Application 3/2025/0363

PLANNING APPLICATION: 3/2025/0363
LAND TO THE REAR OF PENDLE STREET EAST, SABDEN, BB7 9EQ

DRAWING DETAIL
BOUNDARY TREATMENT DETAILS

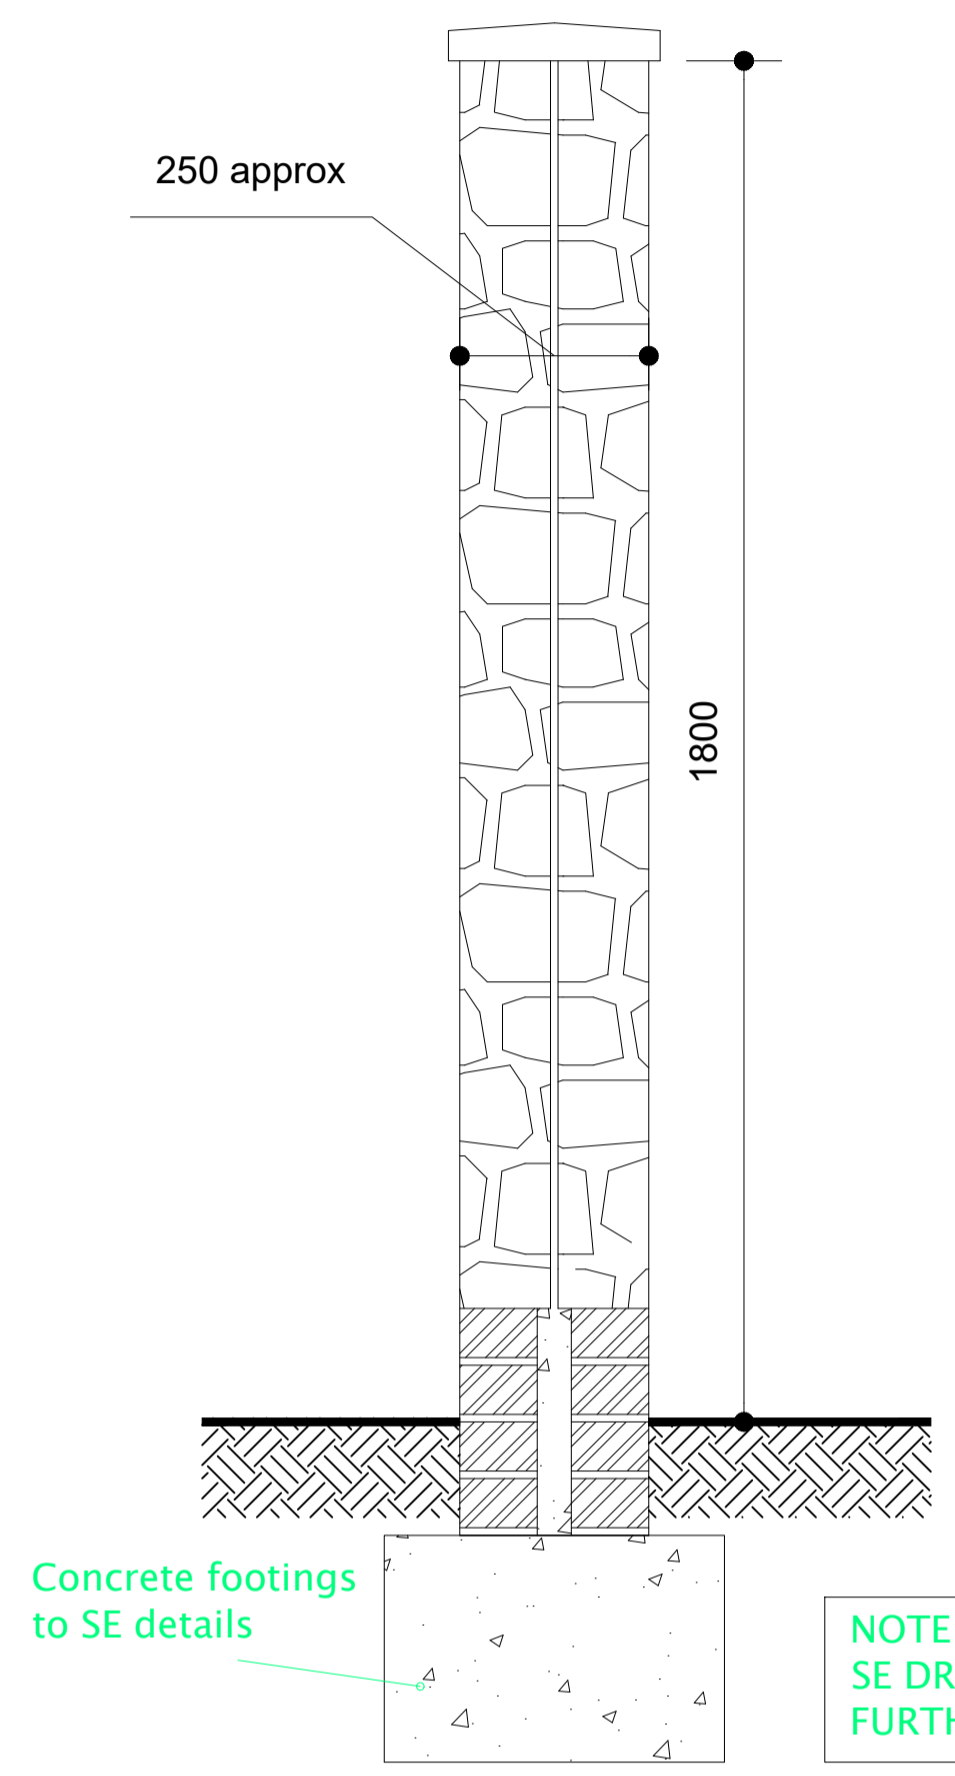
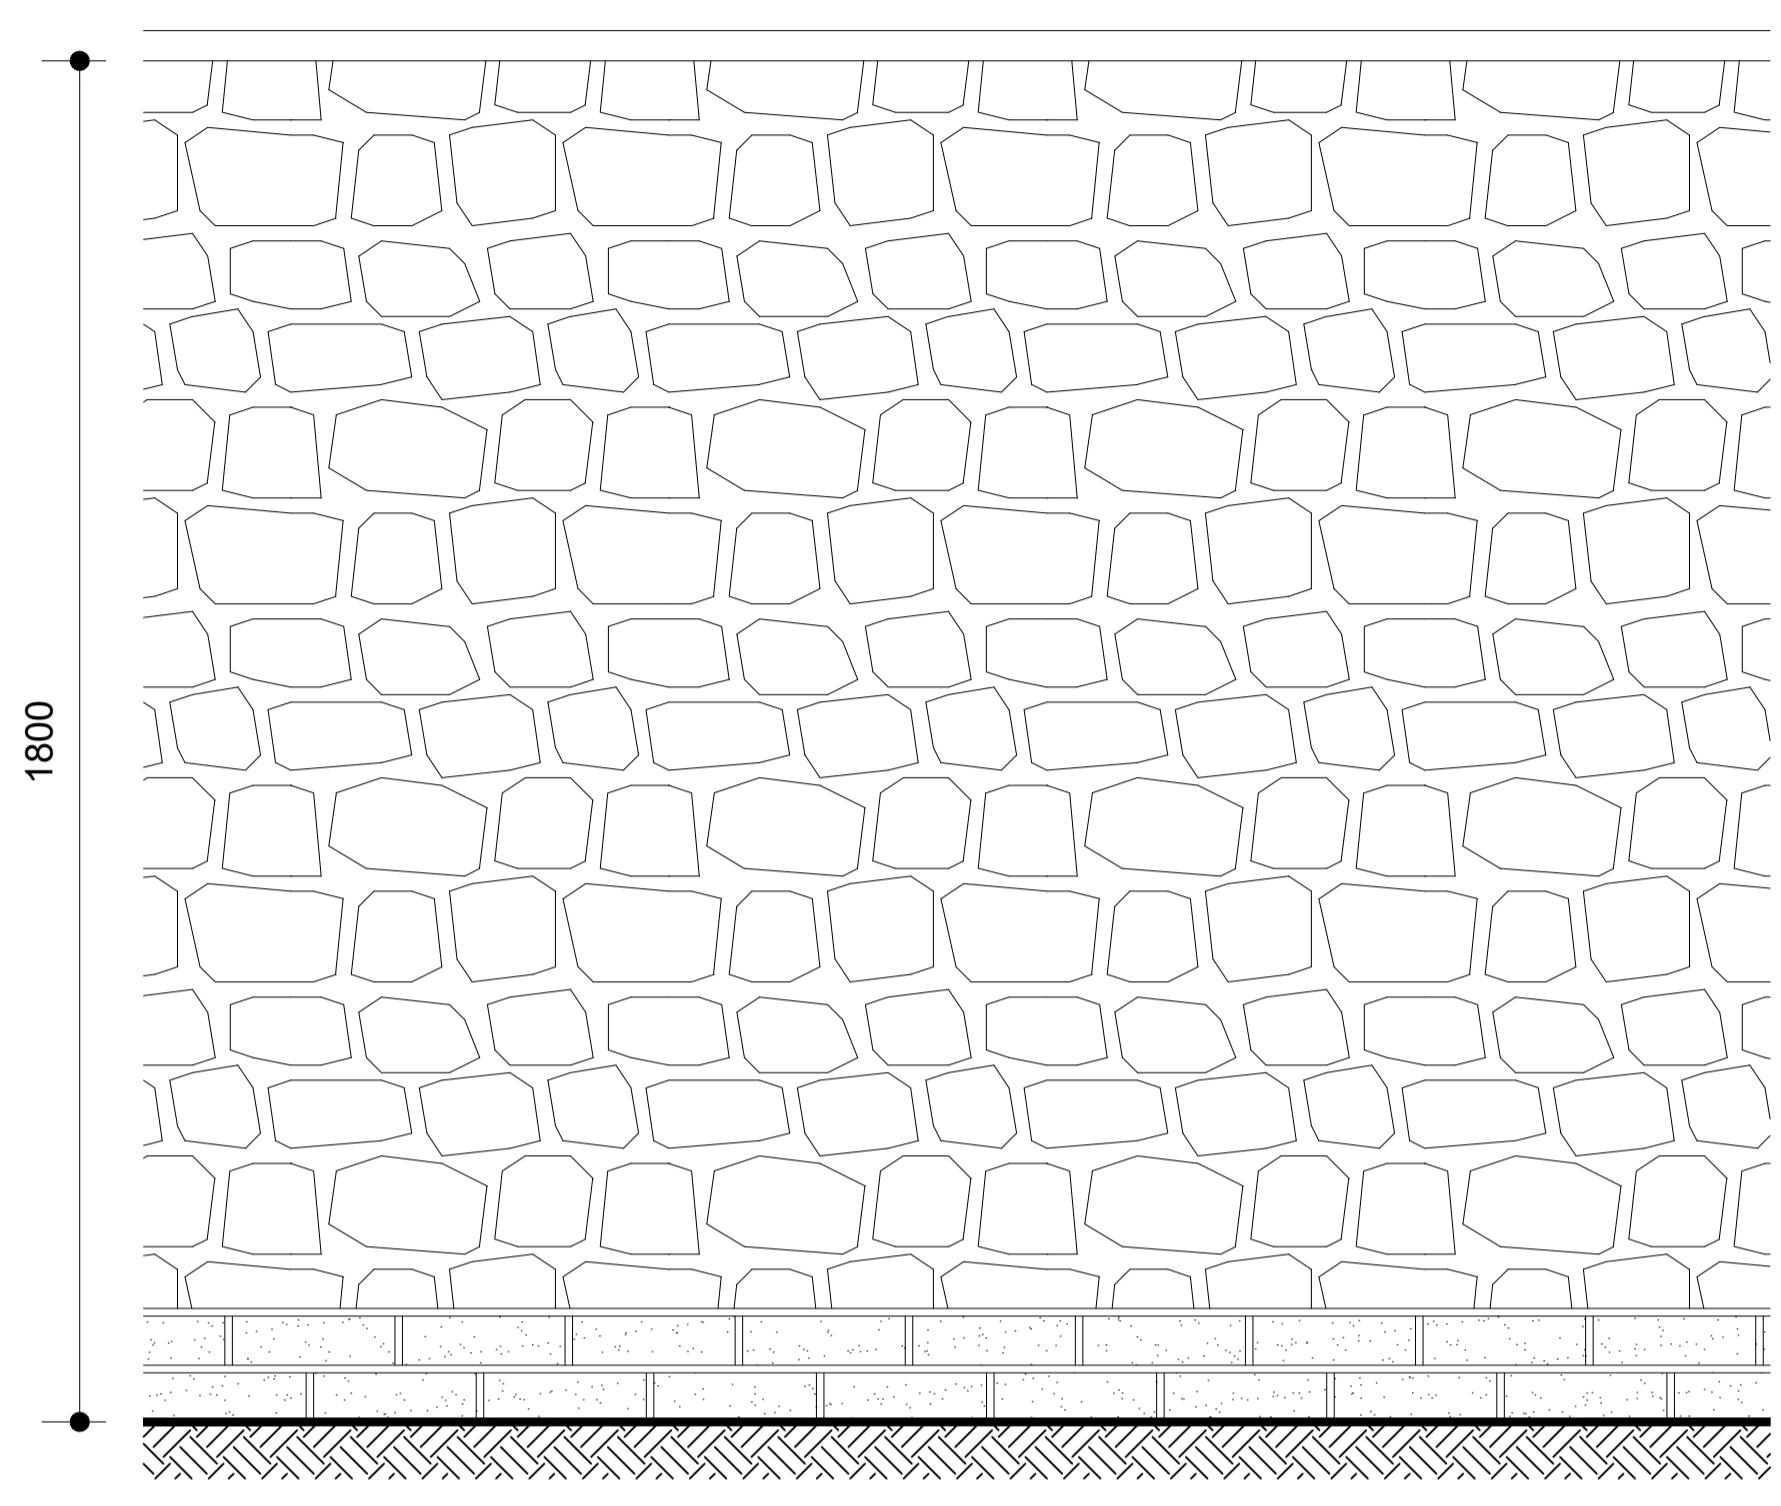
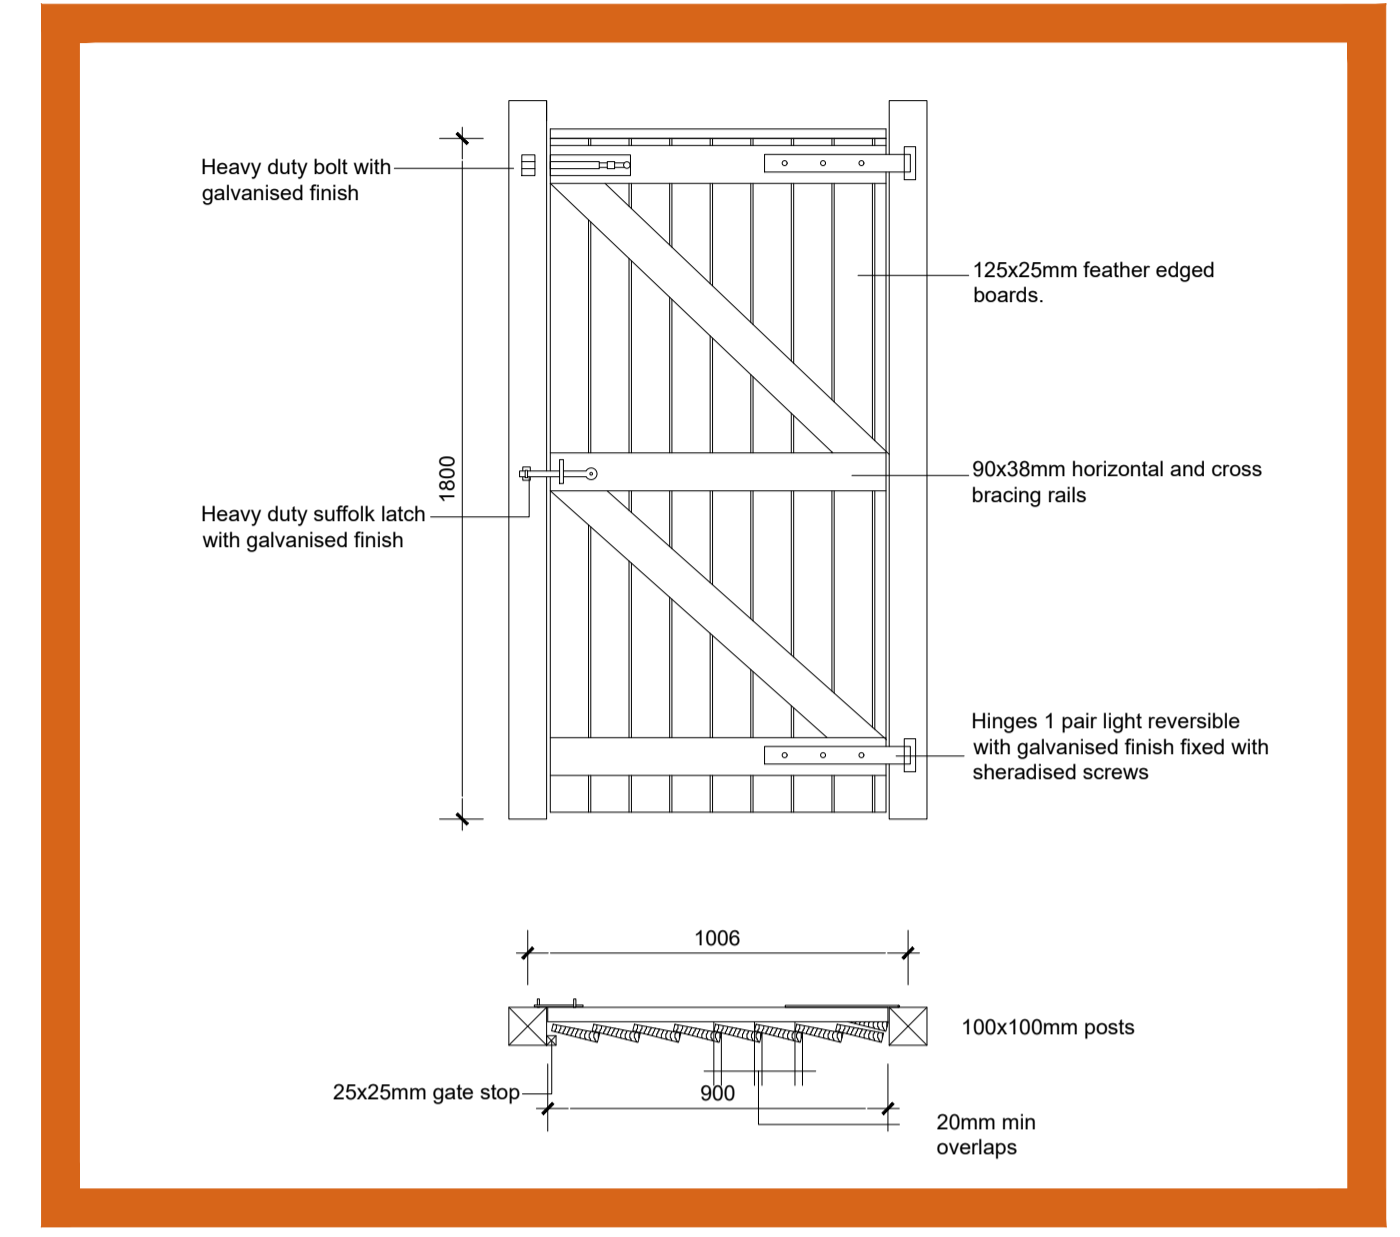
Fence around will be an eyesore and get vandalised and extremely close to football club so will cause issues. A hedge or dry stone wall would be more in keeping.
